**SIZEWELL C PROJECT: TWO VILLAGE BYPASS – BIOSCAN UK LTD COMMENTS ON ECOLOGY (27 JULY 2021)**

On behalf of Farnham Environment Residents and Neighbours (FERN) – PART A

**SIZEWELL C PROJECT: TWO VILLAGE BYPASS – BIOSCAN UK LTD POST-HEARING SUBMISSION ON ECOLOGY (27 JULY 2021)**

On behalf of Farnham Environment Residents and Neighbours (FERN) – PART B

**DRAWING TITLE:**  
 TREE ROOST INSPECTION RESULTS -  
 TWO VILLAGE BYPASS  
 SHEET 3 OF 3

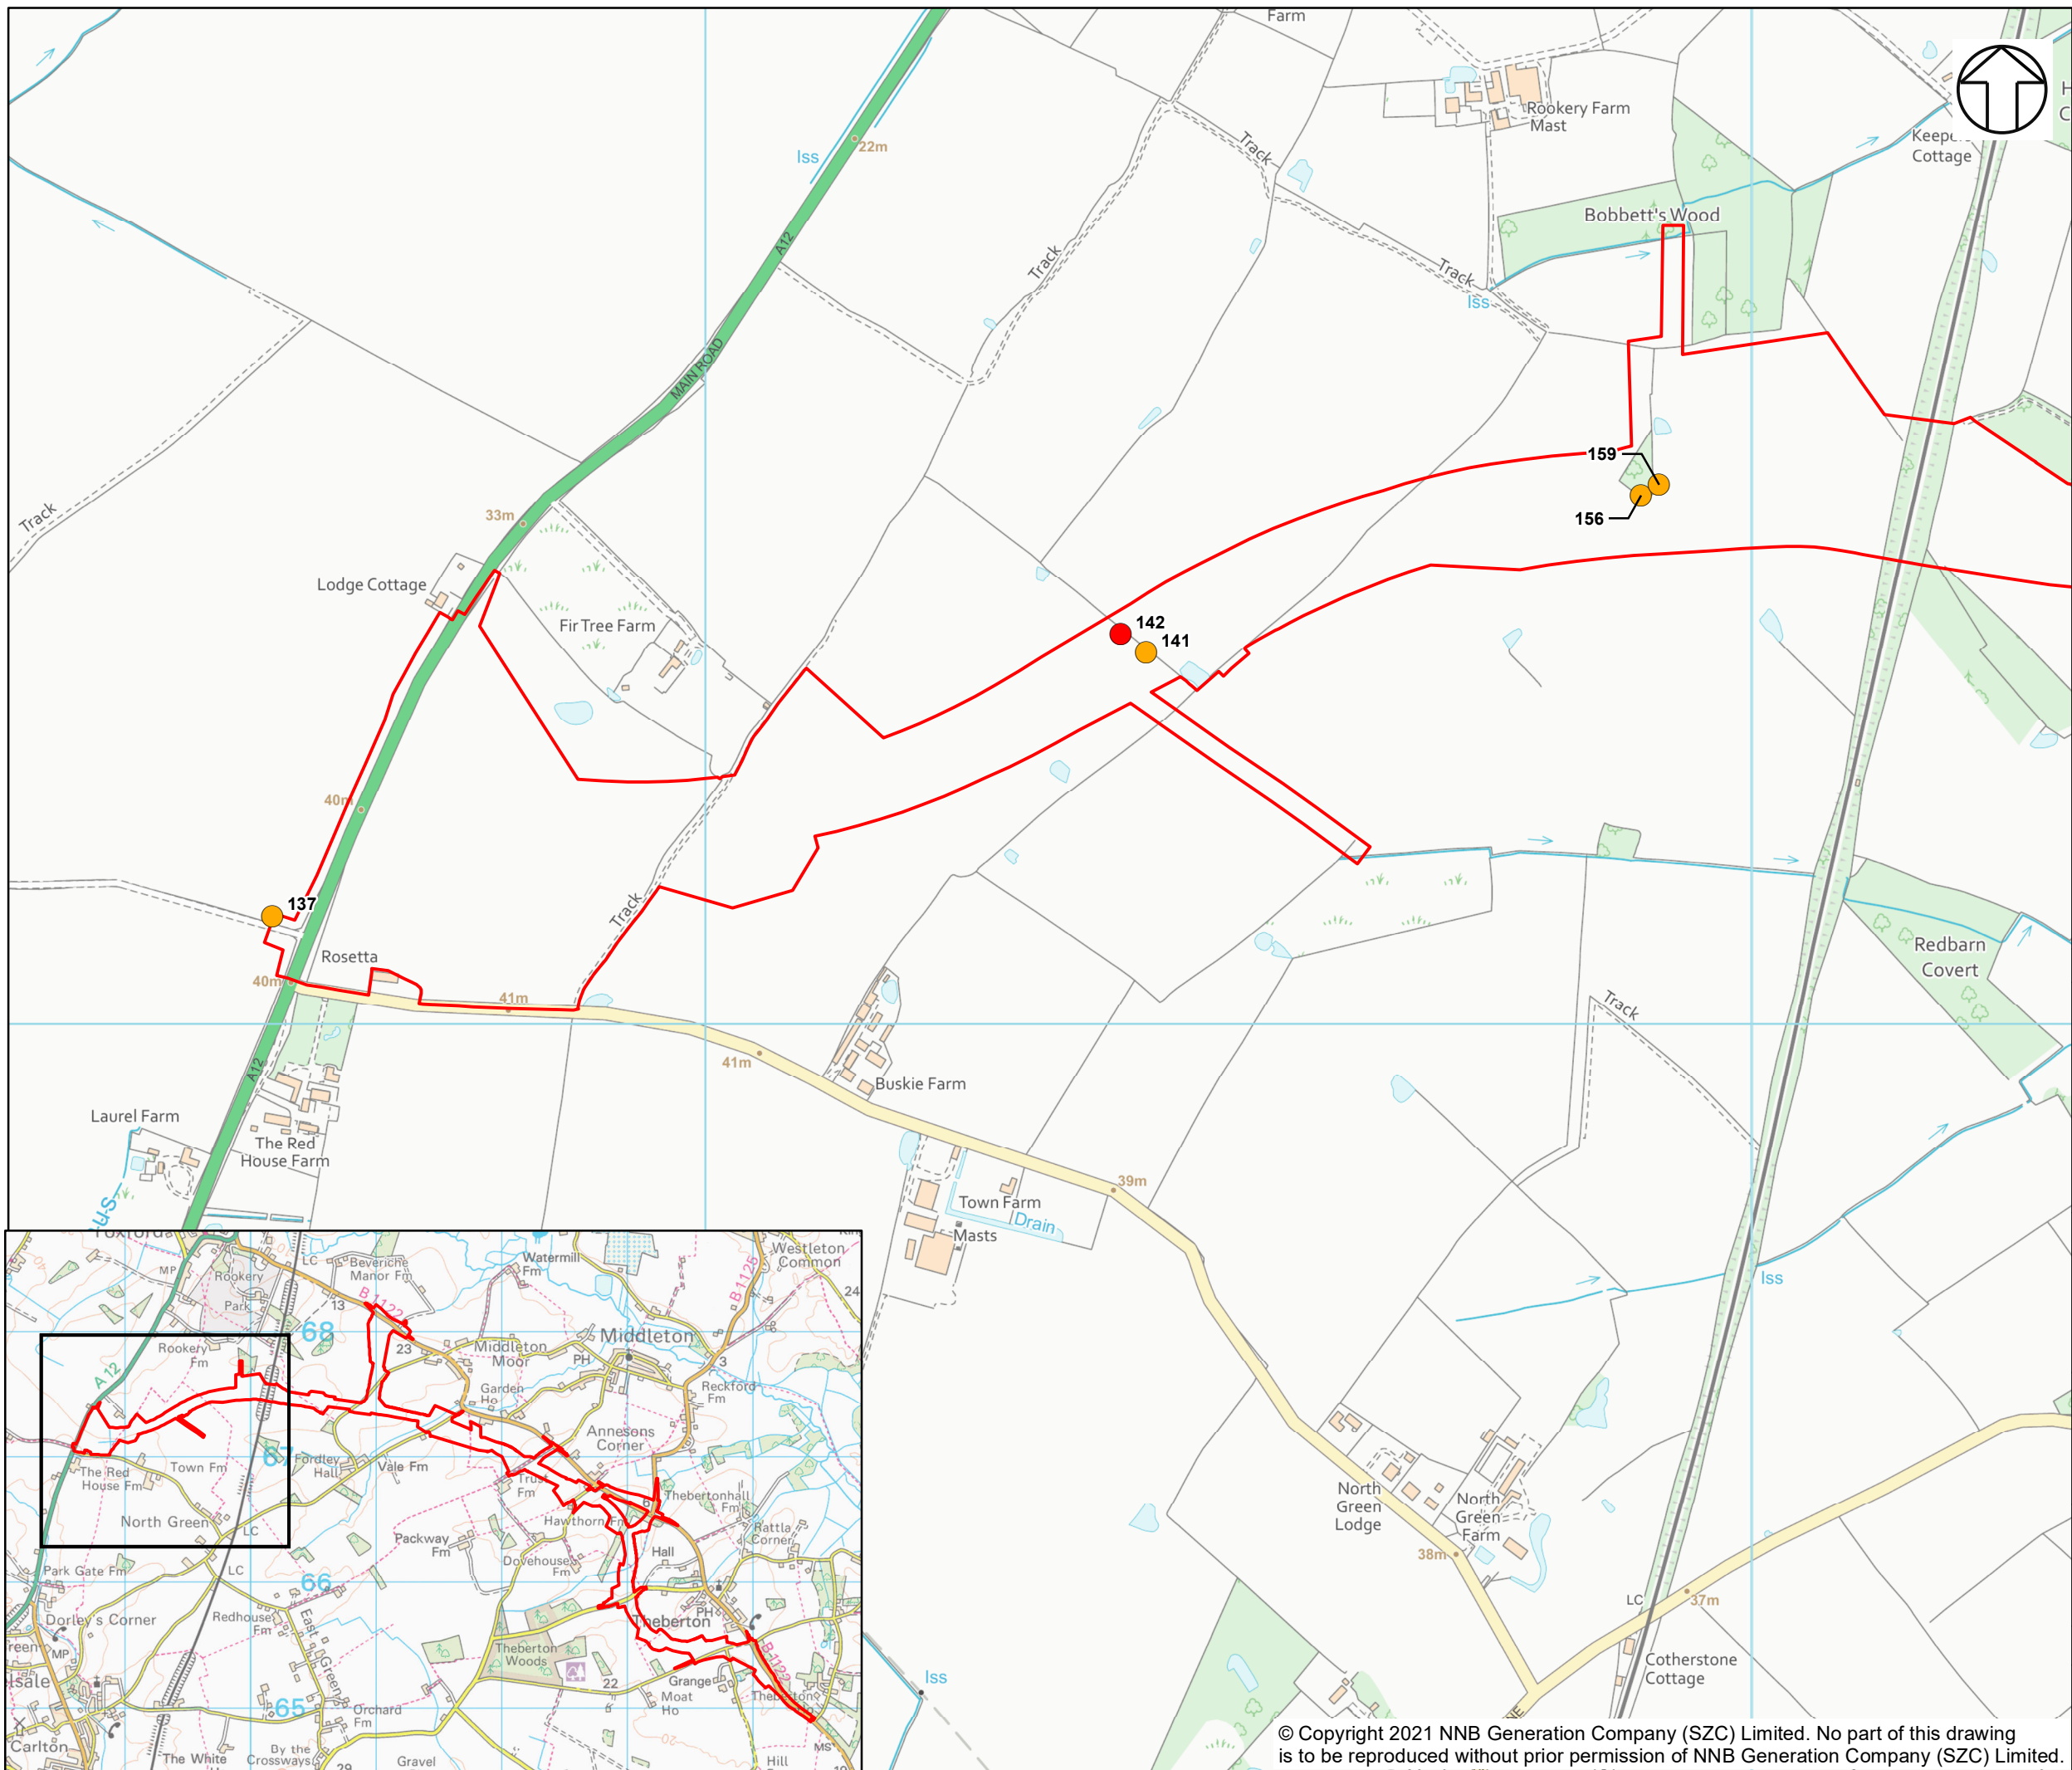
**BATS: tree roosts.** The Applicant has now updated survey information in relation to the assessment of trees for bat roost potential [REP2-121 and REP2-121], which included climbed inspections of the relevant trees in January/February 2021 and/or ground-based assessment. However, given that

reasonable to assume that these trees (identified variously as '207278 and 207279' OR '97 and 98' by the Applicant) may well support a bat roost/s, and the Applicant should provide an assessment on that basis.
